**RE: Lamar Albuquerque, 1600 Airtech Court SE
Grading and Drainage Plan
Engineer's Stamp Date 4-15-2015 (File: M16-D024J1)**

Based upon the information provided in your submittal received 4-17-15, the above referenced plan cannot be approved for Building Permit until the following comments are addressed:

C1.01

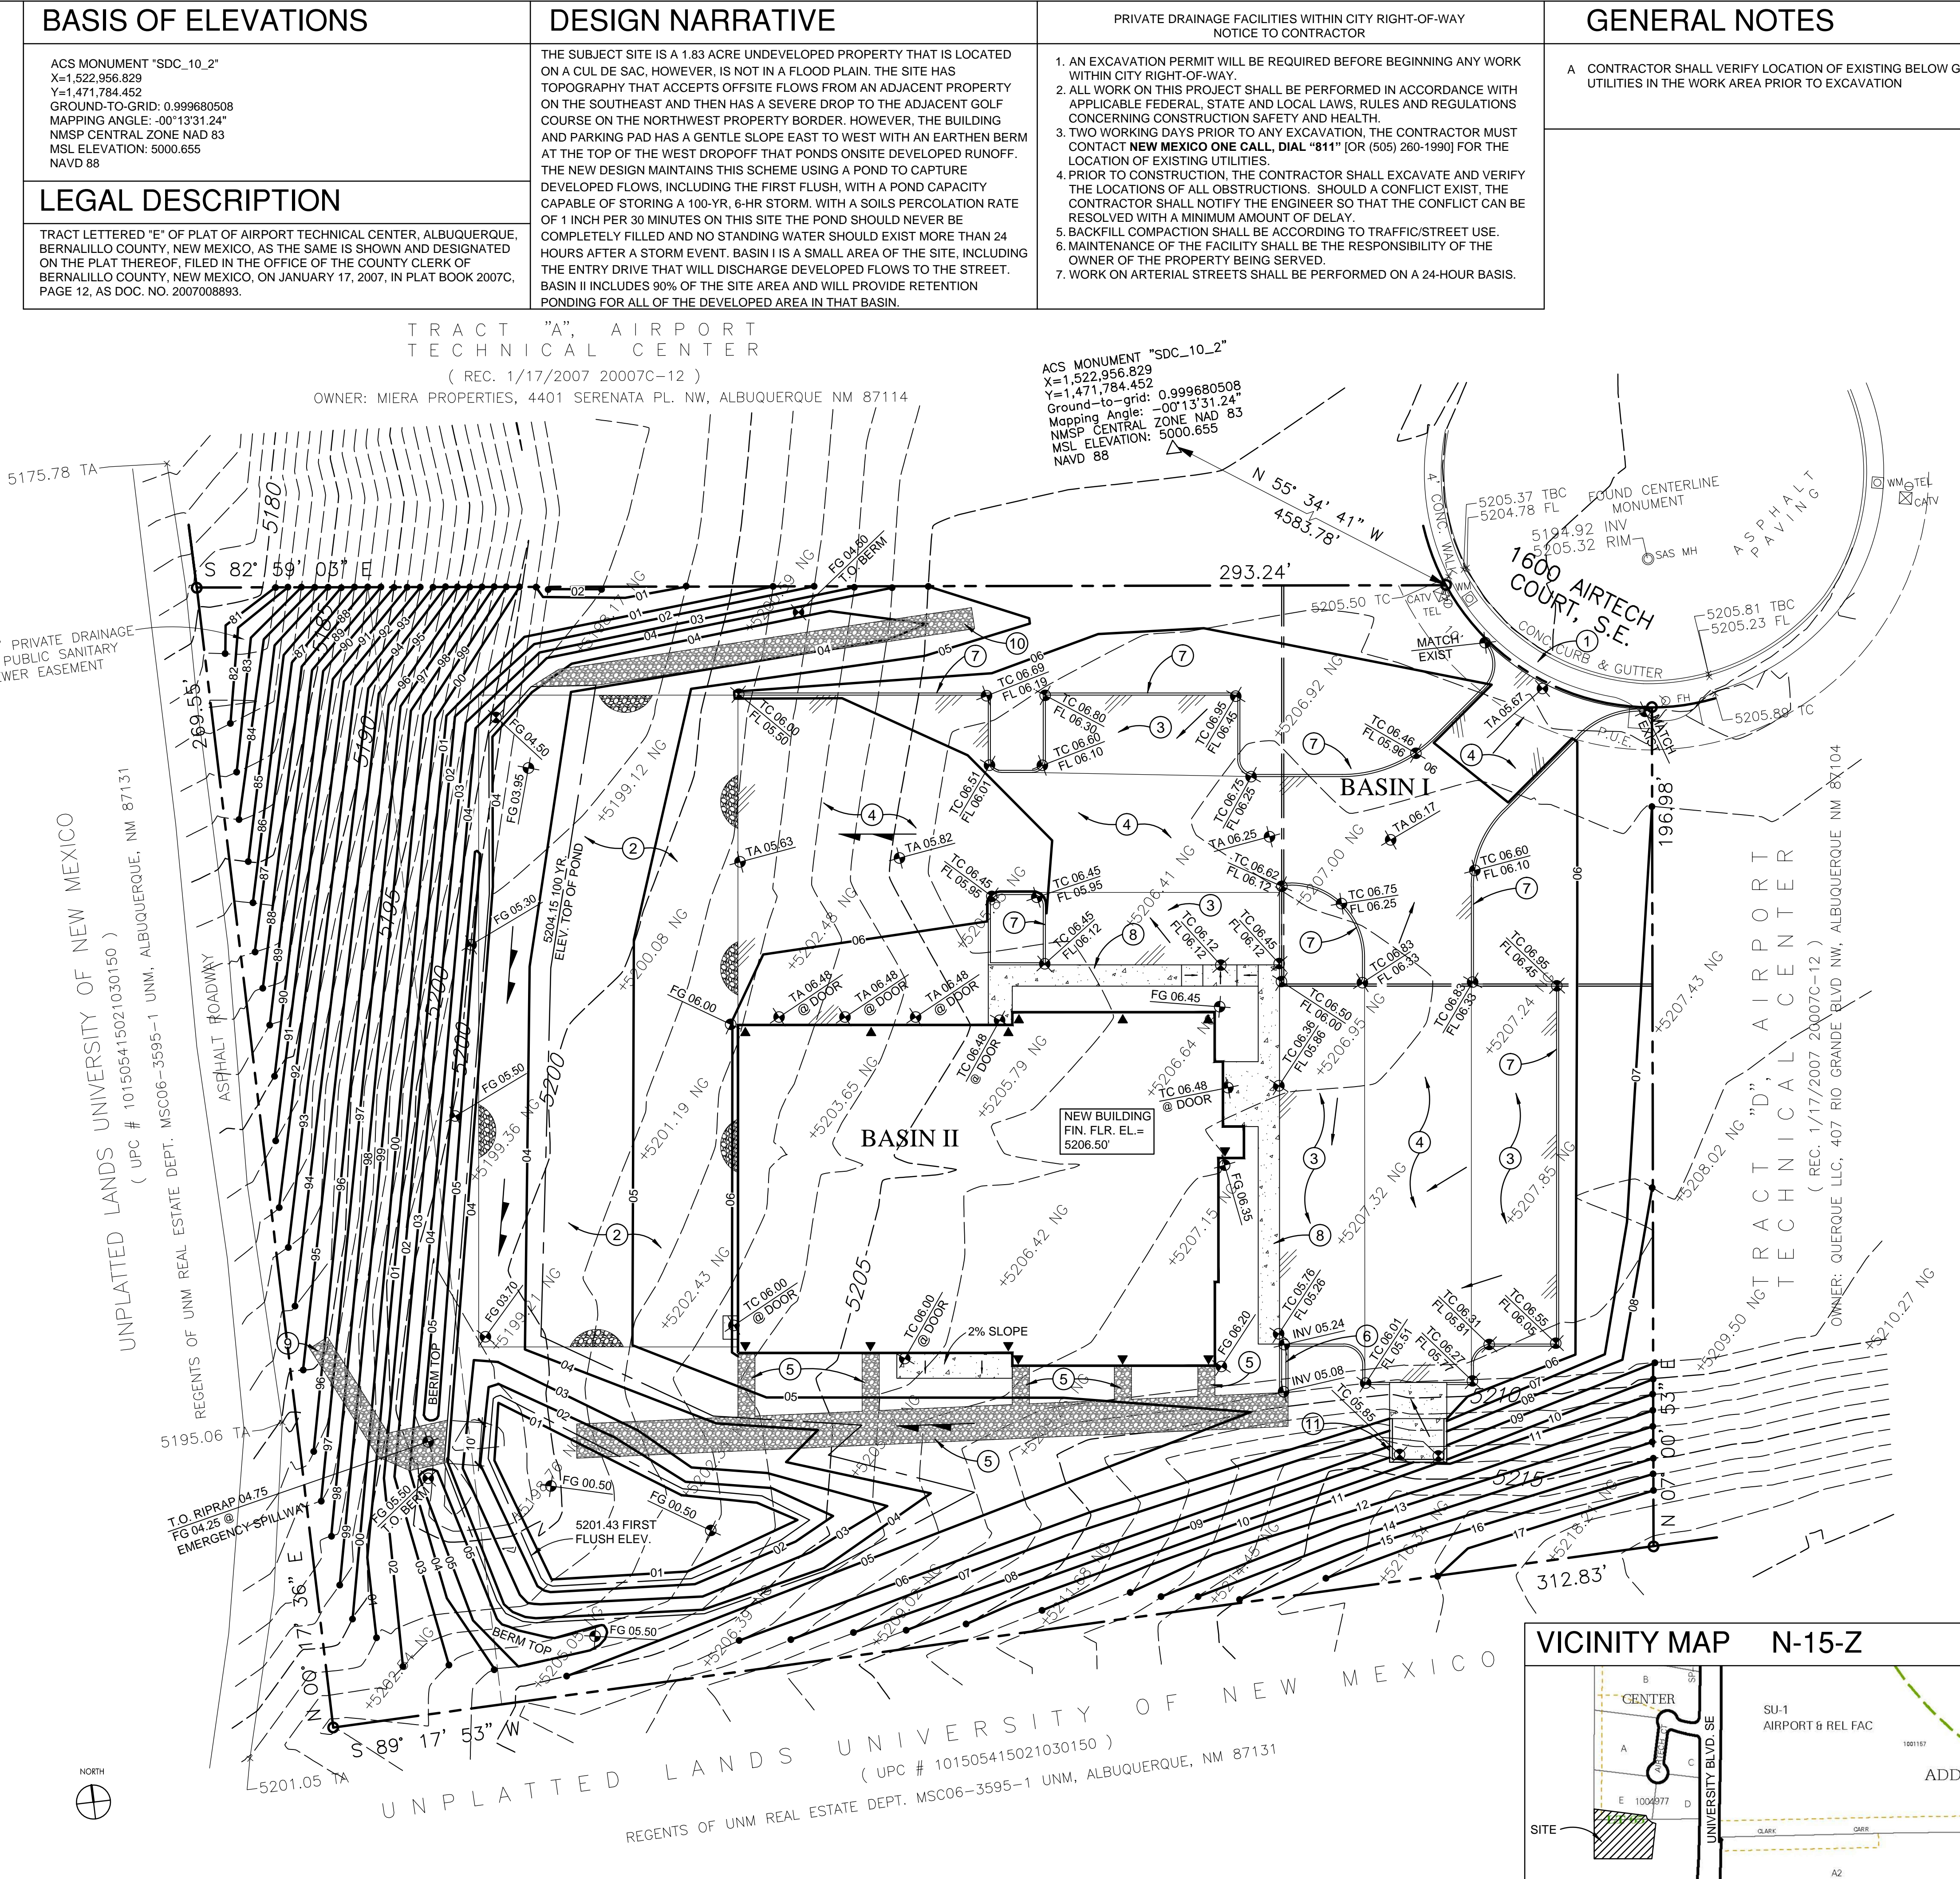
- 1) Show basin boundaries to show the boundary between Basin I and Basin II. Provide legend for a basin boundary.
- 2) In the "Drainage Narrative", indicate that the site is not within a floodplain.

- 3) The new contours are shown to direct some drainage to the property north of the subject site. Minimize impact to the property to the north by providing a swale along the south side of the property line.

- 4) Because the pond does not drain within 6 hours, it must be sized to handle the 100-year 24-hour storm volume according to the information you have provided. Size the pond according to the calculations you have provided for the 100-year 24-hour runoff volume. If you can provide the background geotechnical information for the percolation rate provided, percolation rate credit may be allowed according to new DPM requirements in order to reduce pond volume requirements. Adjust the WSEL of the pond accordingly.

- 5) Provide an emergency spillway from the pond to the west to follow historical flow patterns in case the pond overtops. Provide riprap from the emergency spillway to the property line.
- 6) On the plans where a swale is shown and flow is concentrated, provide riprap to protect the slope. This would include riprap within the requested swale along the north property line and swales that are being directed into the proposed pond.
